Consultation Response from KC,
Lead Local Flood Authority

2025/90387 Site of Former Perseverance House, St Andrew's Road, Huddersfield, HD1 6RZ

Discharge of details reserved by conditions 3 (Phase I Desk Study Report), 4 (Phase II Intrusive Site Investigation Report), 10 (materials), 12 (drainage strategy), 13 (temp surface water strategy), 15 (interceptor details) on previous permission 2024/91336 for erection of two storey office/workshop with detached store and associated works

Documents reviewed by the LLFA:

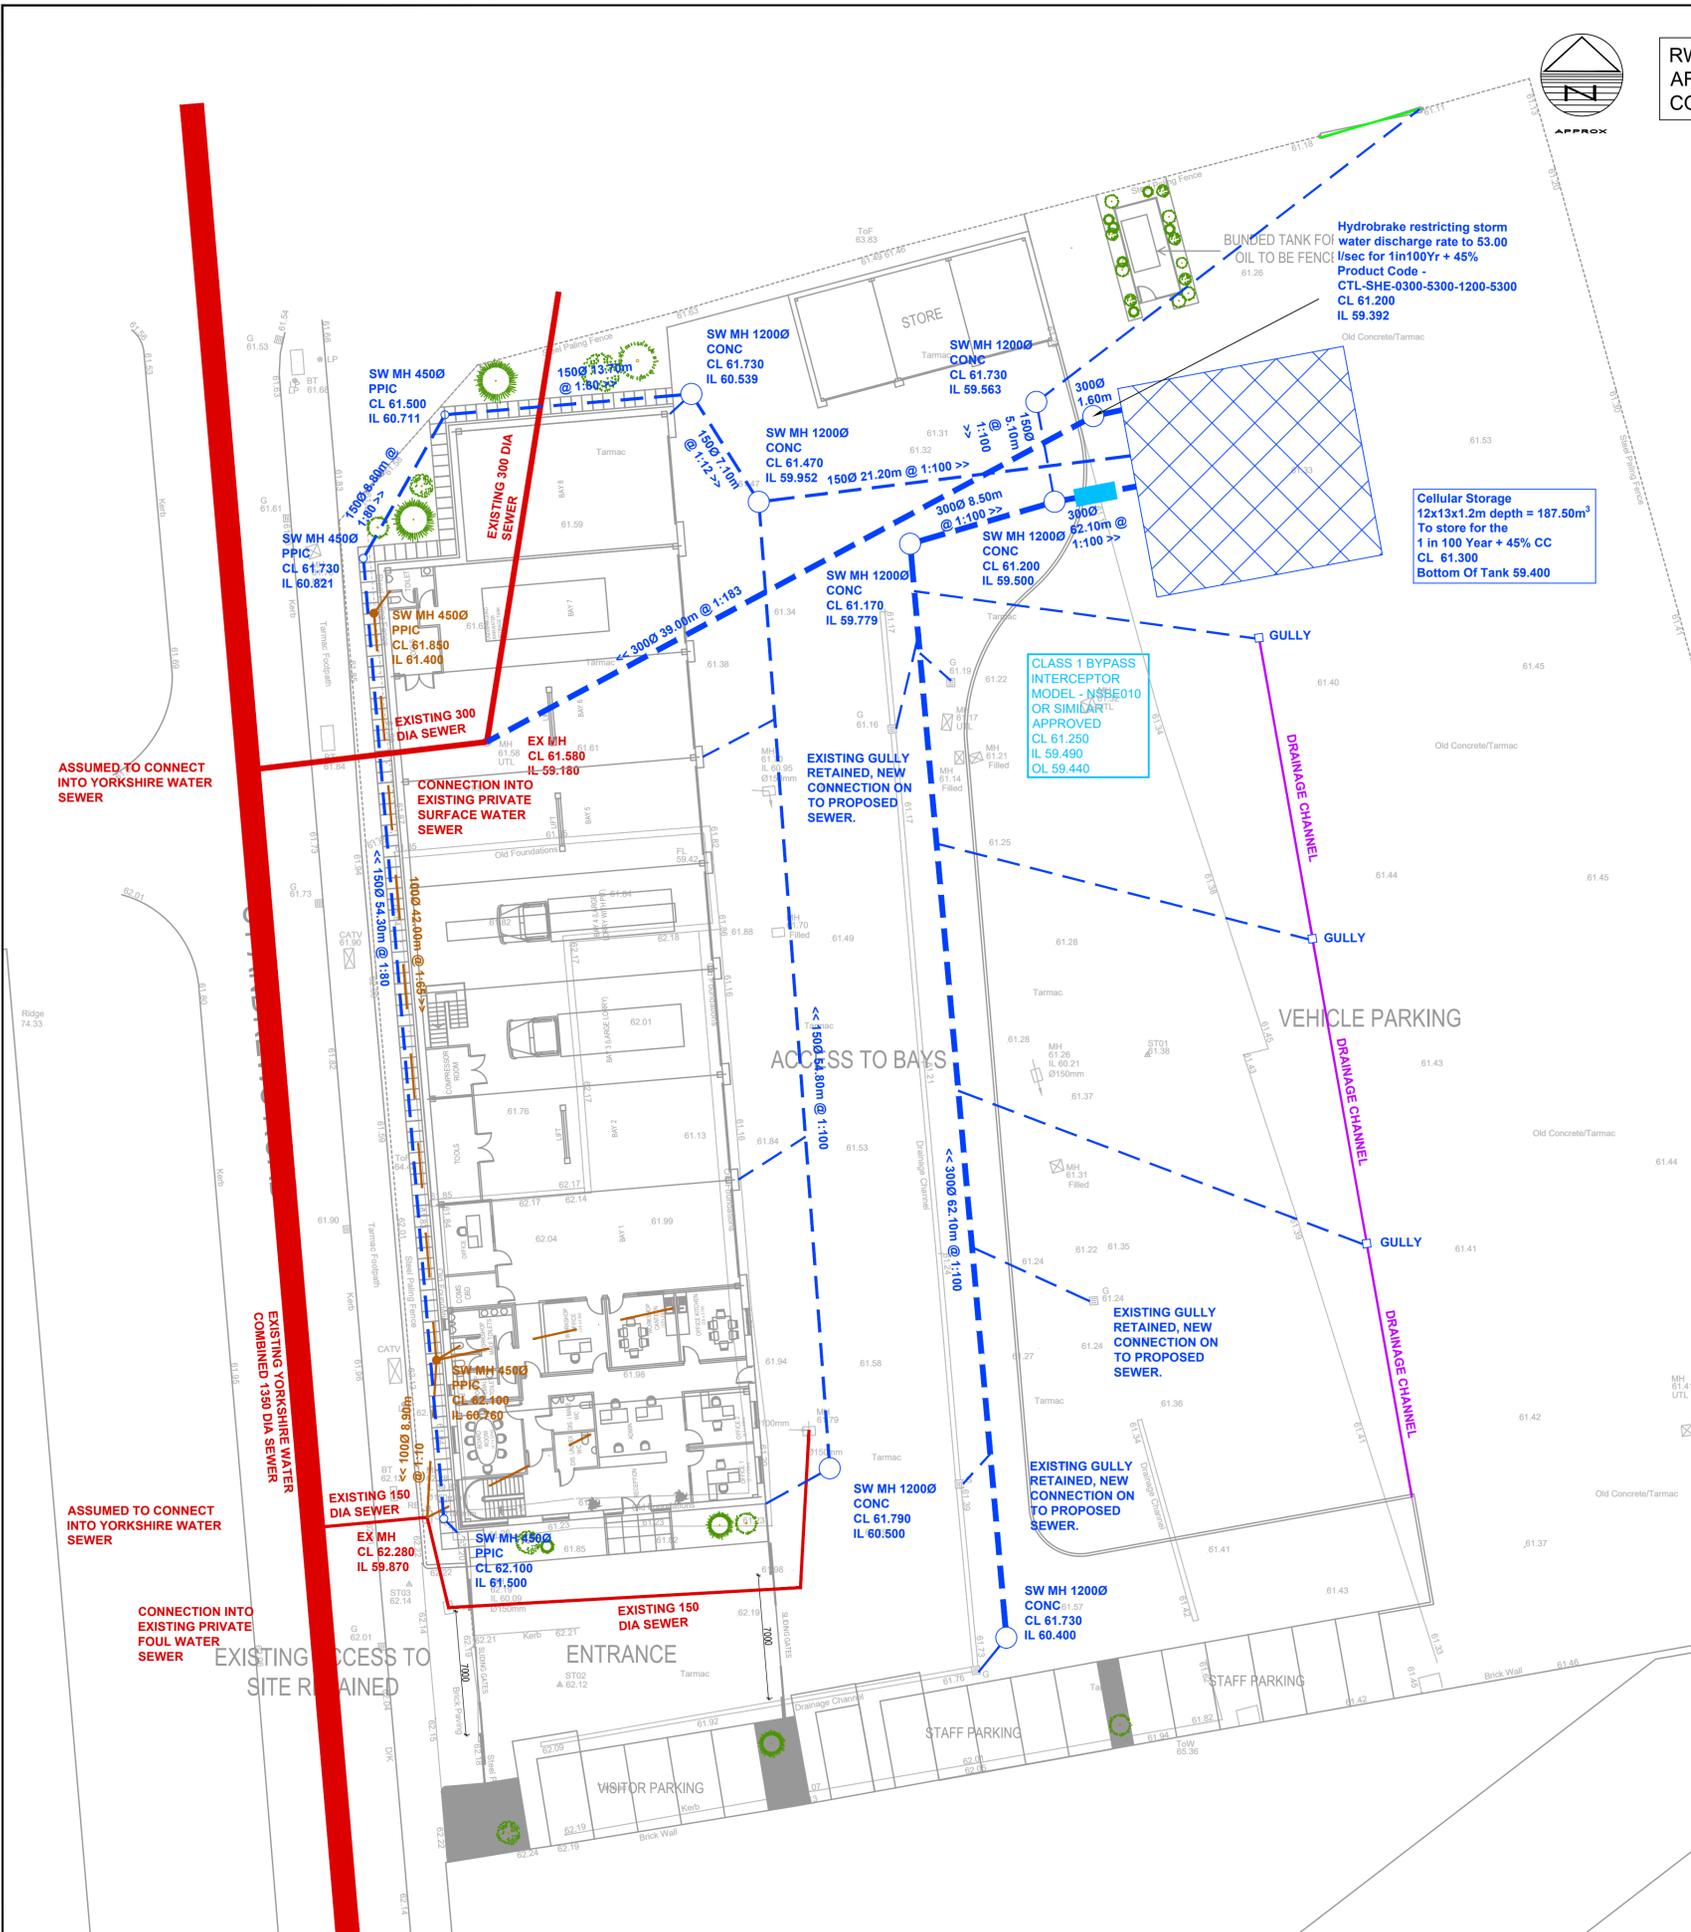
1. No access into the attenuation tank is shown on drawing 24466-DR-C-0100 – how does the developer plan to inspect and maintain the tank?
2. There appears to be clashes between the inlet and outlet pipes adjacent to the tank – e.g. the Hydrobrake Chamber IL is 59.392 and the pipe diameter is 0.3m giving a top of pipe at approx. 59.690, however the pipe crossing the attenuation pipe outlet appears to be at an IL of approx. 59.530 which will clash with the outlet pipe. A check for pipe clashes should also be undertaken for the tank inlet pipe from the building.

No information regarding the temporary drainage arrangements has been submitted. Therefore Condition 13 **cannot be** discharged

Therefore Condition 12 **cannot be** discharged until the above changes have been made.
